**Application no: 21/01857/DISC**

**Location:** Greensquare Homes Limited, Former Bodicote Farm, White Post Road, Bodicote, Banbury

## **Transport Development Control**

Project		
BODICOTE Near Banbury		
Drawing Title		
Site Safety Logistics Plan		
File Location: S:\TEAM ASSET MANAGEMENT\2019 PROJECTS		
Date	Status	
16/11/2020	Provisional	
Scale	Drawn by	Checked by
1:500 @ A1	MS	-
Project No.	Drawing No.	Revision
22-029	C/SL/115	/ C

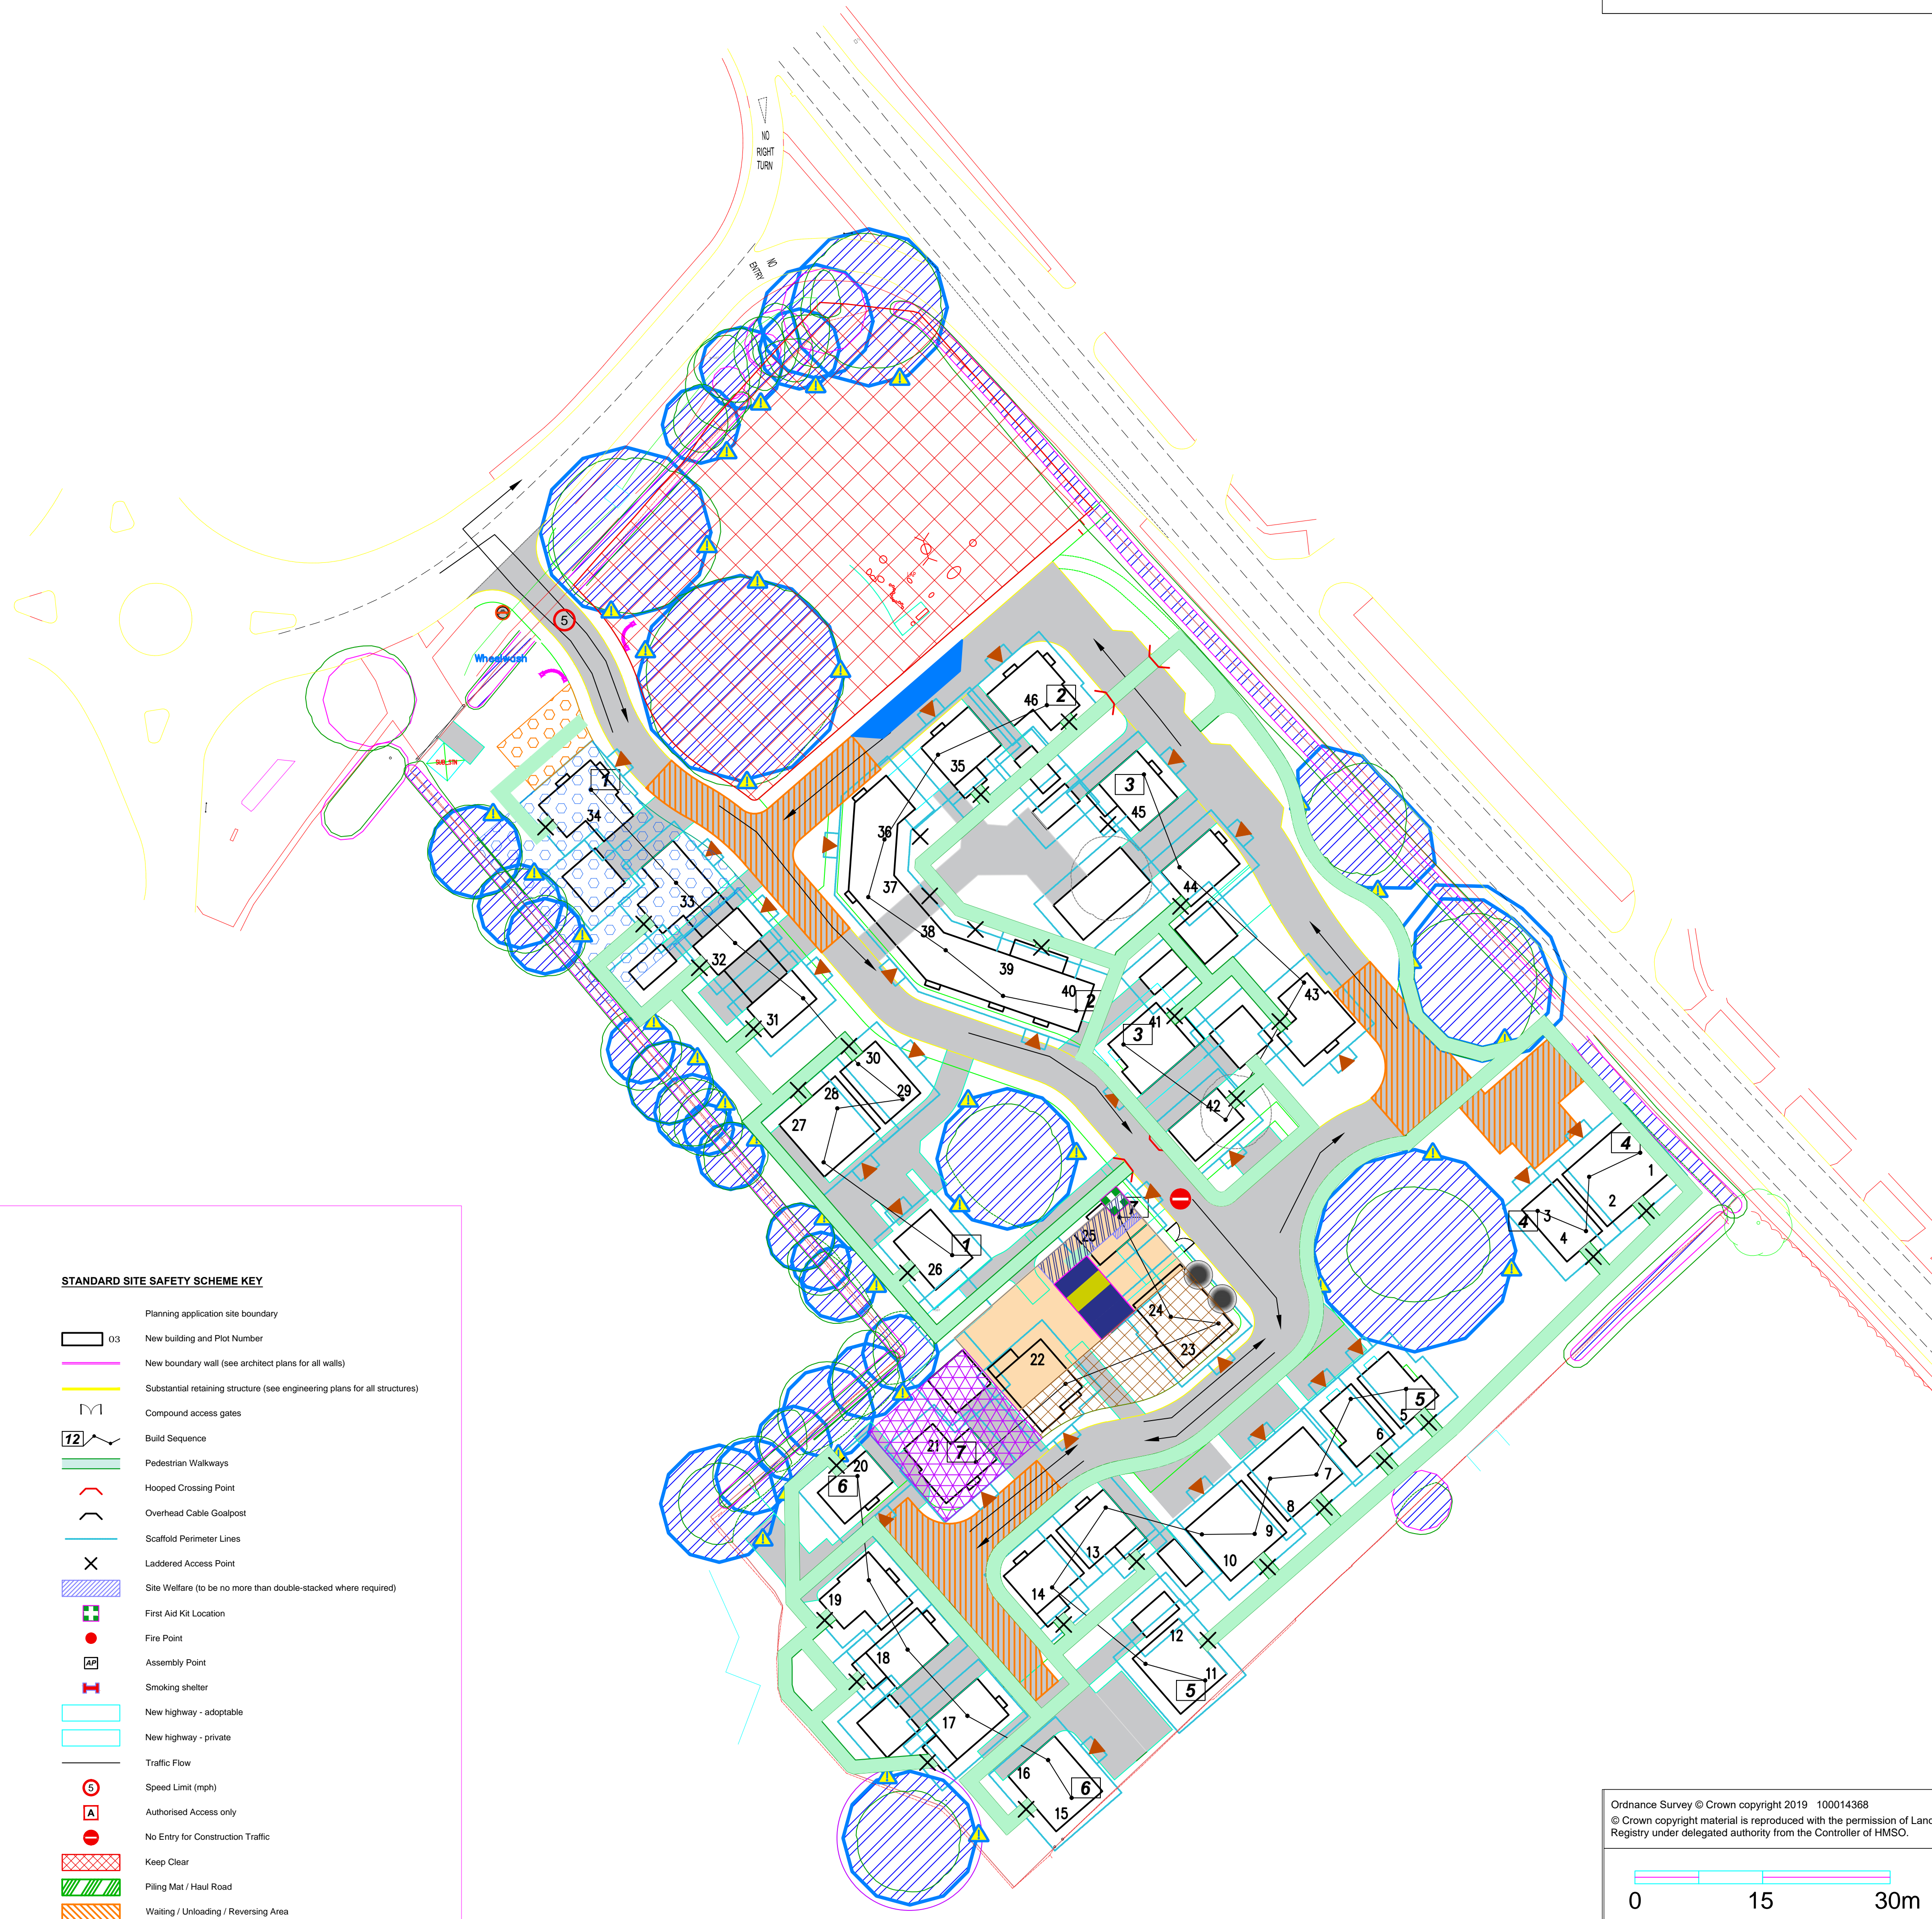
The Method Statement says that site staff parking will be as shown on the Site Safety and Logistics Plan, drg. no. 0737\_115A. This drawing does indicate Contractor Parking in the Key with brown cross-hatch shading, but I am unable to see any areas on the plan given over to this use. This needs to be rectified before the condition may be approved.

With regard to Traffic Management, the Method Statement gives a written description of the permitted routes but it would greatly benefit from a marked-up plan which can be provided to all delivery companies. In particular, HGVs using the A361 must continue into Banbury where it meets the A4260 - they must not use minor roads (e.g. Wykham Lane) as a short cut to access the site.
